PR-2023-009260

SD-2023-00211 -VACATION OF RIGHT-OF-WAY

REQUEST: VACATION OF THE ENTIRETY OF KNOTTS LANDING COURT NW FOR USE AS A FUTURE PRIVATE DRIVEWAY TO ACCESS NEW HOUSING UNITS AND A COMMUNITY BUILDING

Development Facilitation Team (DFT) – Review Comments

Platwork Drawn Checked
 BM CLW JSN
 Date: December 2024
 Scale: Horizontal 1" = 60'
 Project No: 2431460
 Sheet: 2 OF 3

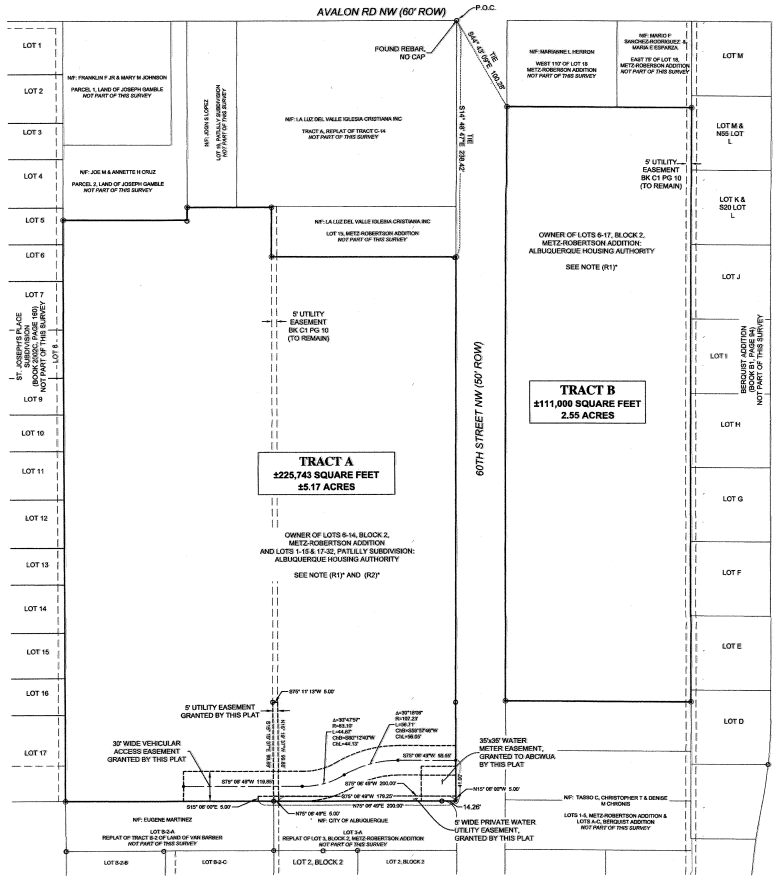
1. The Water Authority has no objection to the vacation of Knotts Landing Court NW. However, existing lot B-2-A (address 107 Knotts Landing Ct) may be land-locked. The subject site needs to have access to public water and public sanitary sewer infrastructure. There is potential access to the west along the property boundary between Lot B-2-A and C-15-A.

1 TCL - Overall Site Plan
 1" = 30'-0"

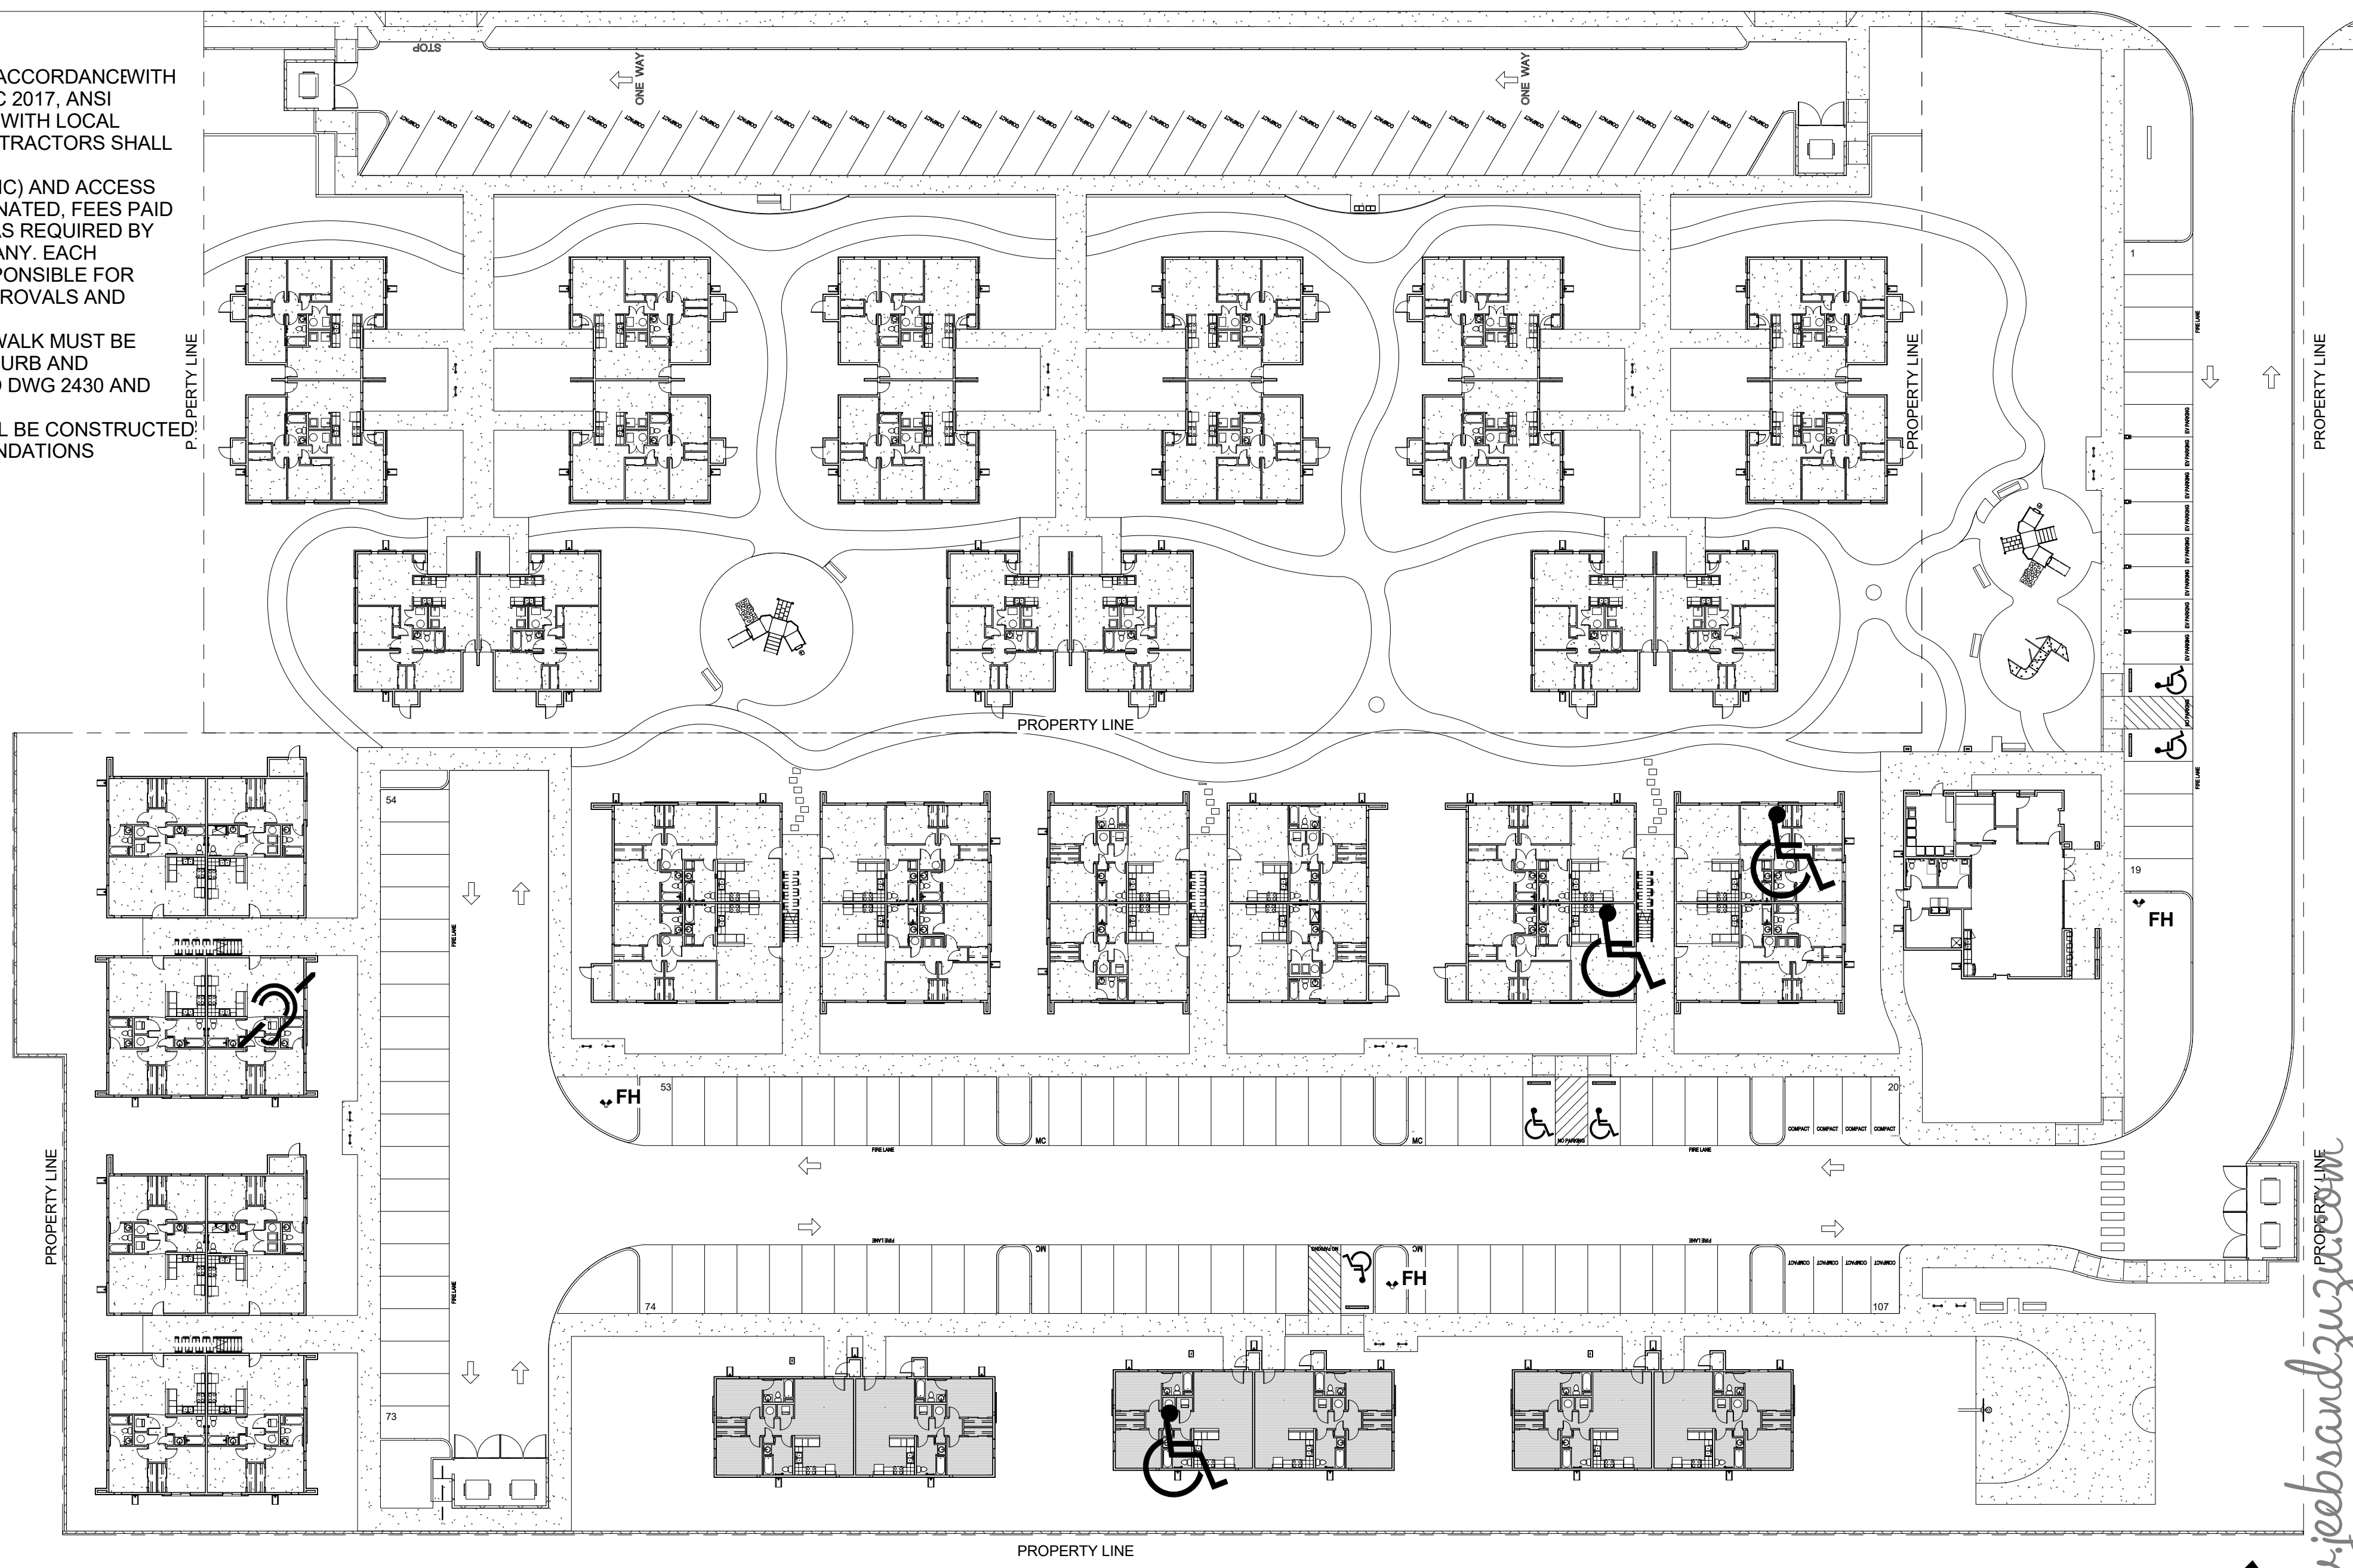
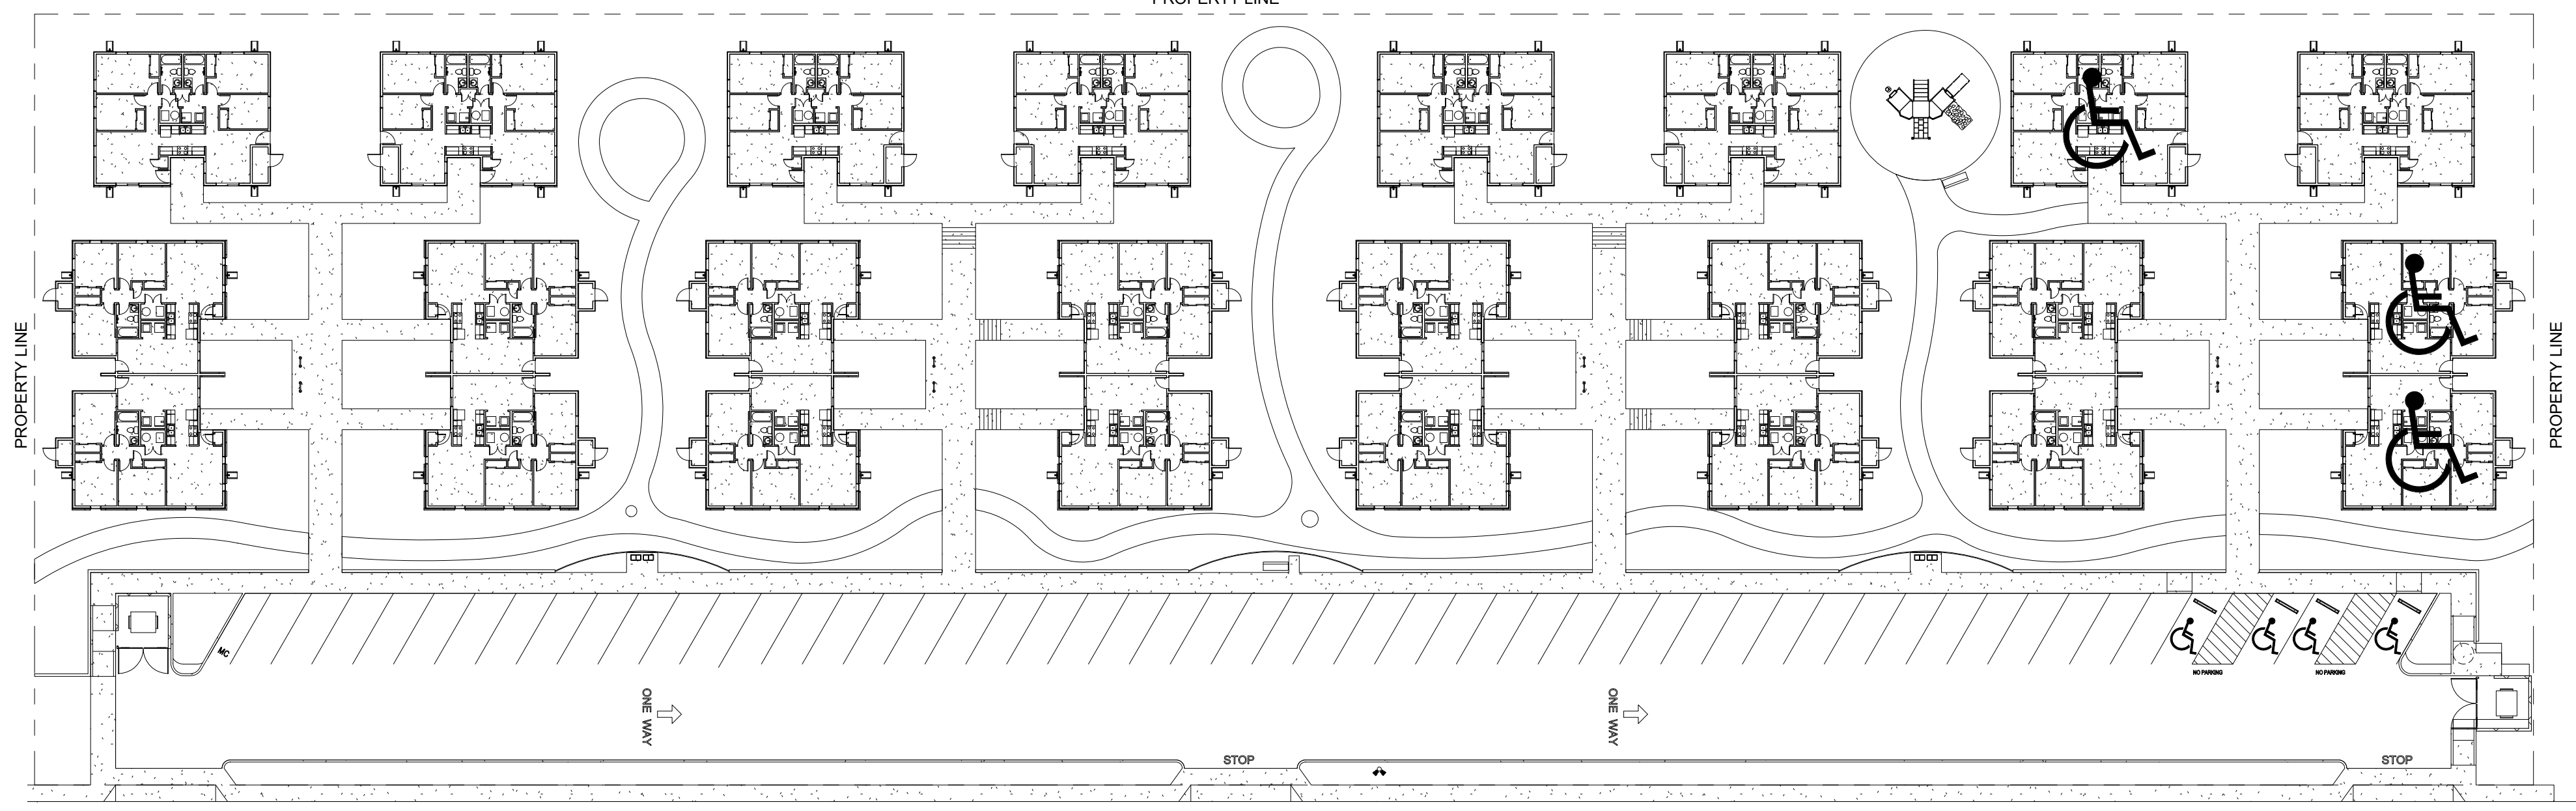
1. Transportation has no objection to the Vacation.
2. Please note prior to replat, 60th St. is a local road and requires 5' sidewalks with a 4'-6' landscape buffer. Sidewalk is shown on the plan but there are no dimensions given. Please provide a cross section of 60th showing sidewalks, curb and gutter and ROW lines. Please ensure ROW meets minimum required in the DPM. All work in the ROW needs to be placed on an Infrastructure List and be done through work order.
3. An approved TCL is required prior to Site plan or building permit. Please fill out a Traffic Scoping Form and submit to Matt Grush mgrush@cabq.gov to determine if a traffic study is required.
